MECKLENBURG COUNTY
Park and Recreation Department

MEMORANDUM

DATE: January 25, 2024

RE: Rezoning Petition #2023-162
PID# 18312111

RZ-100

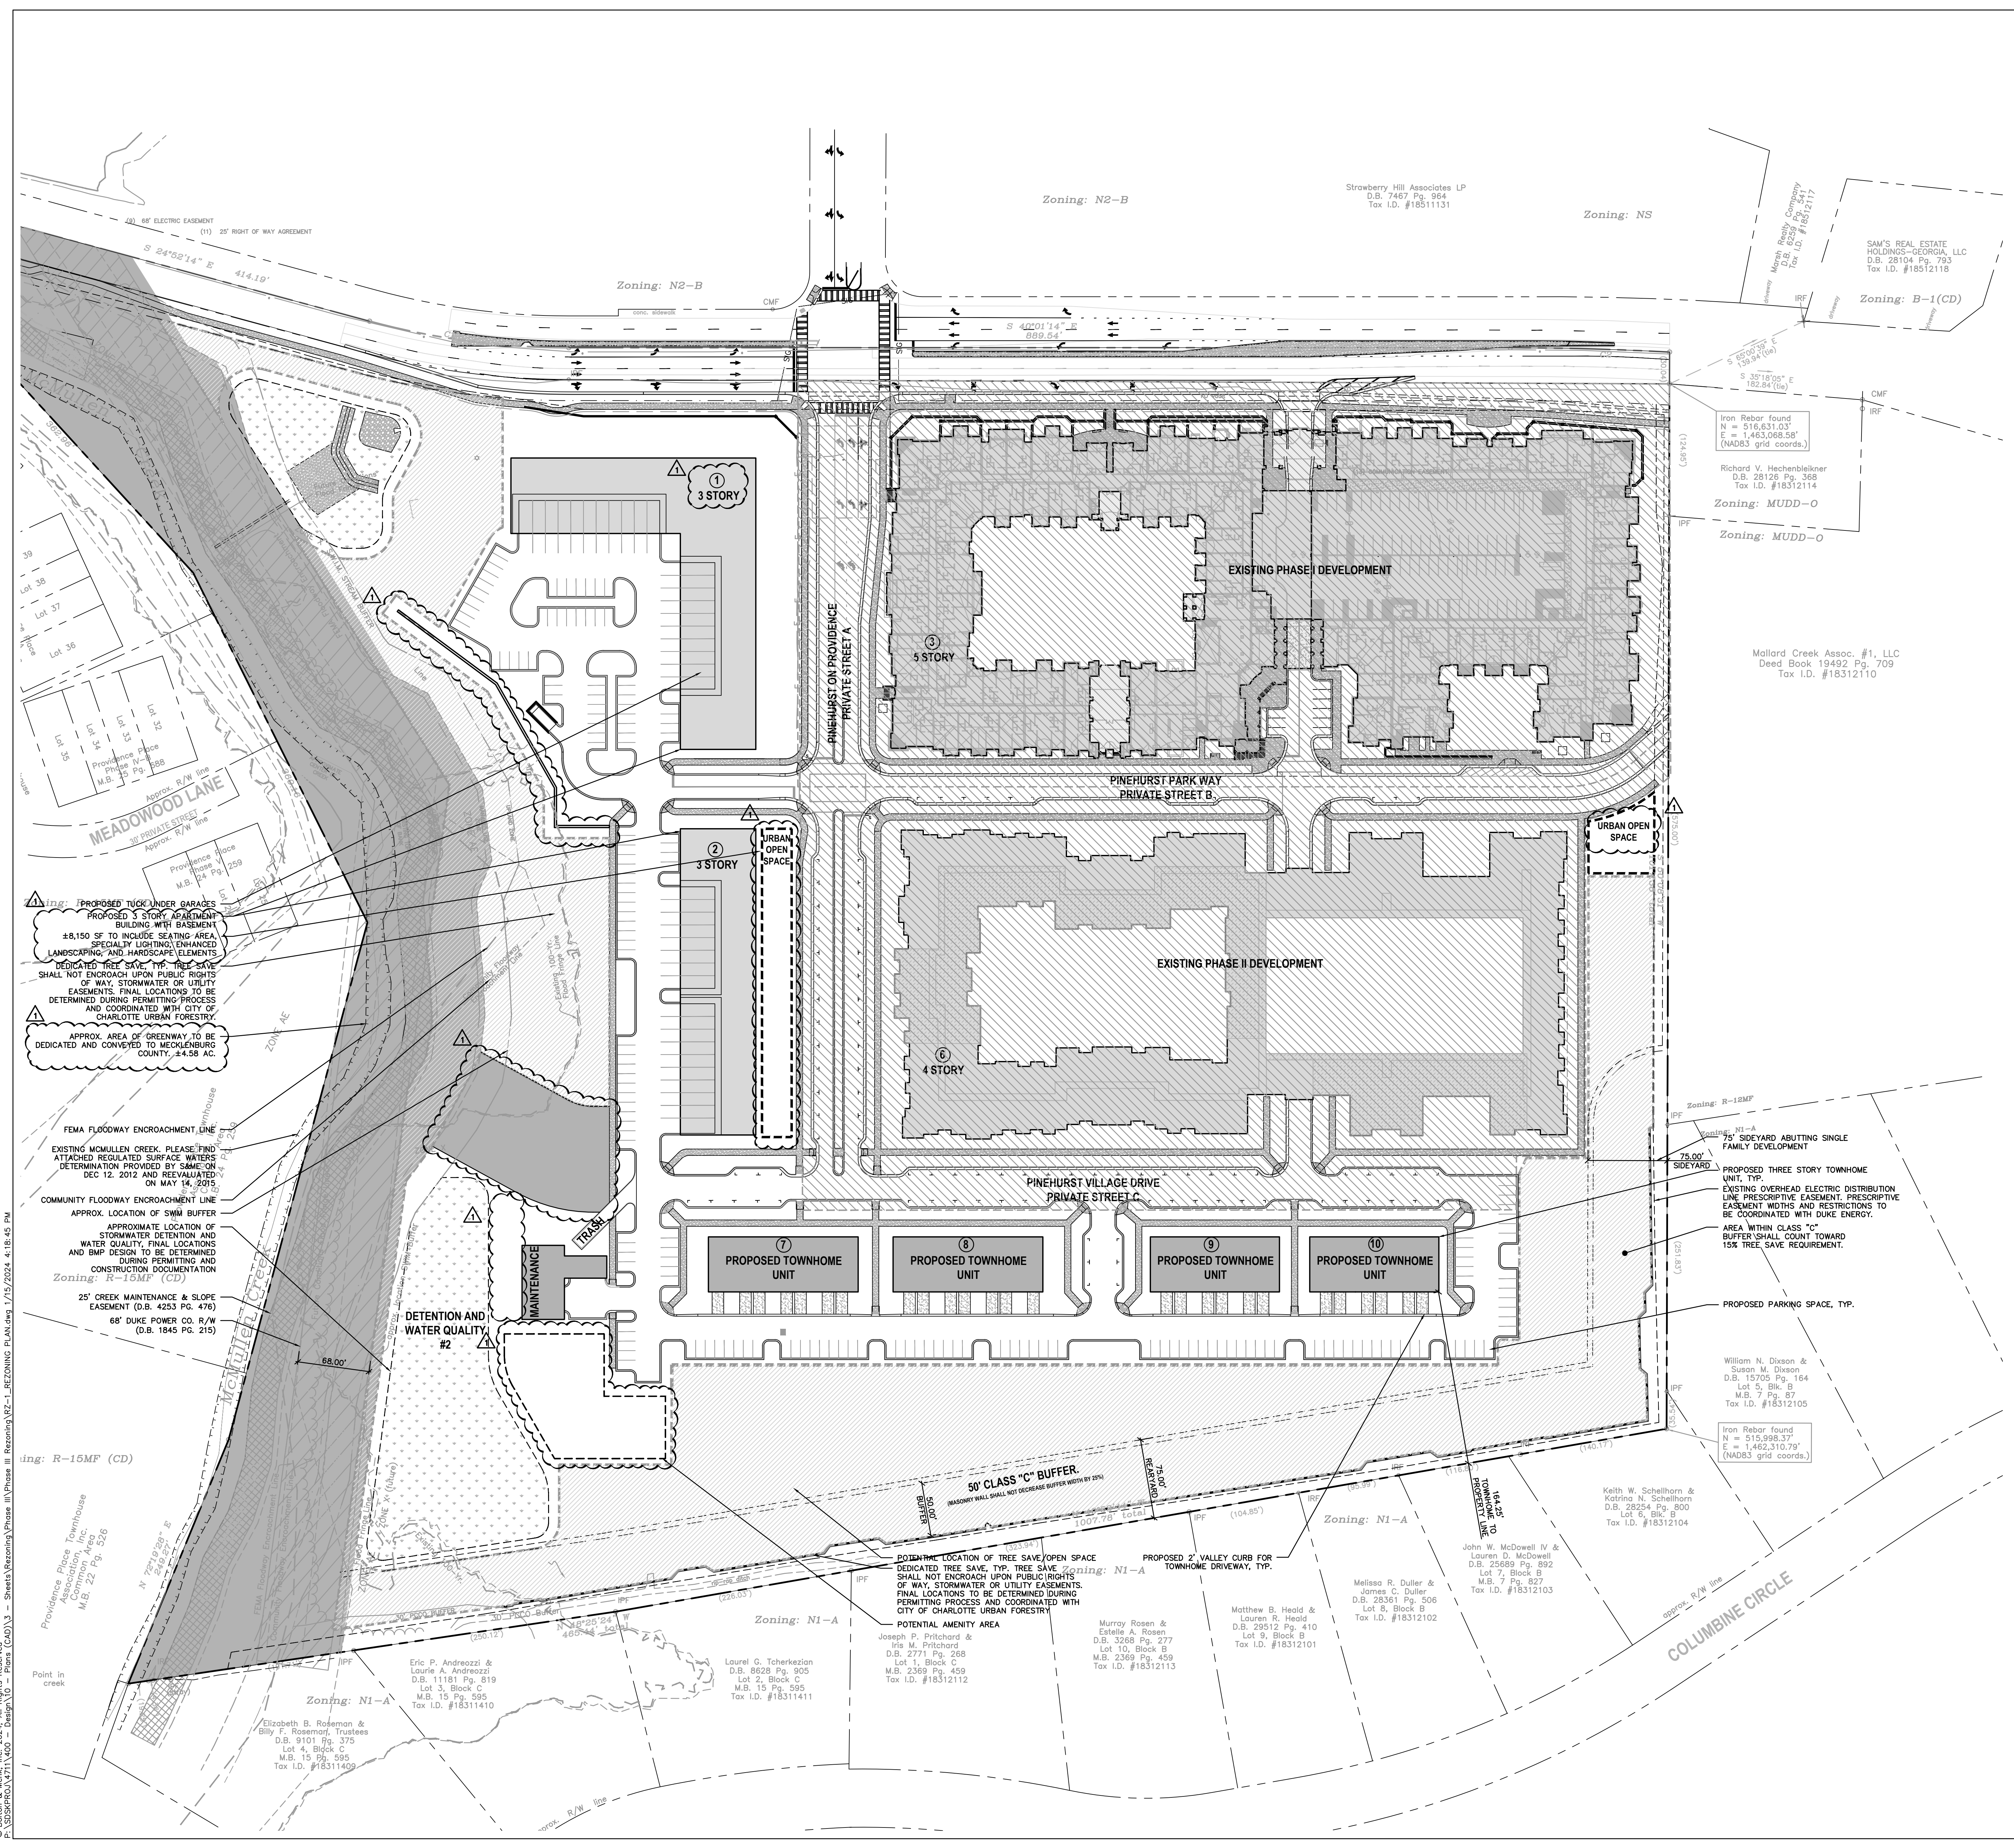
The proposed greenway access easement must connect to the public street ROW to provide Mecklenburg County access to the greenway dedication area. This easement shall overlap with the private street between the public street ROW and the greenway area.
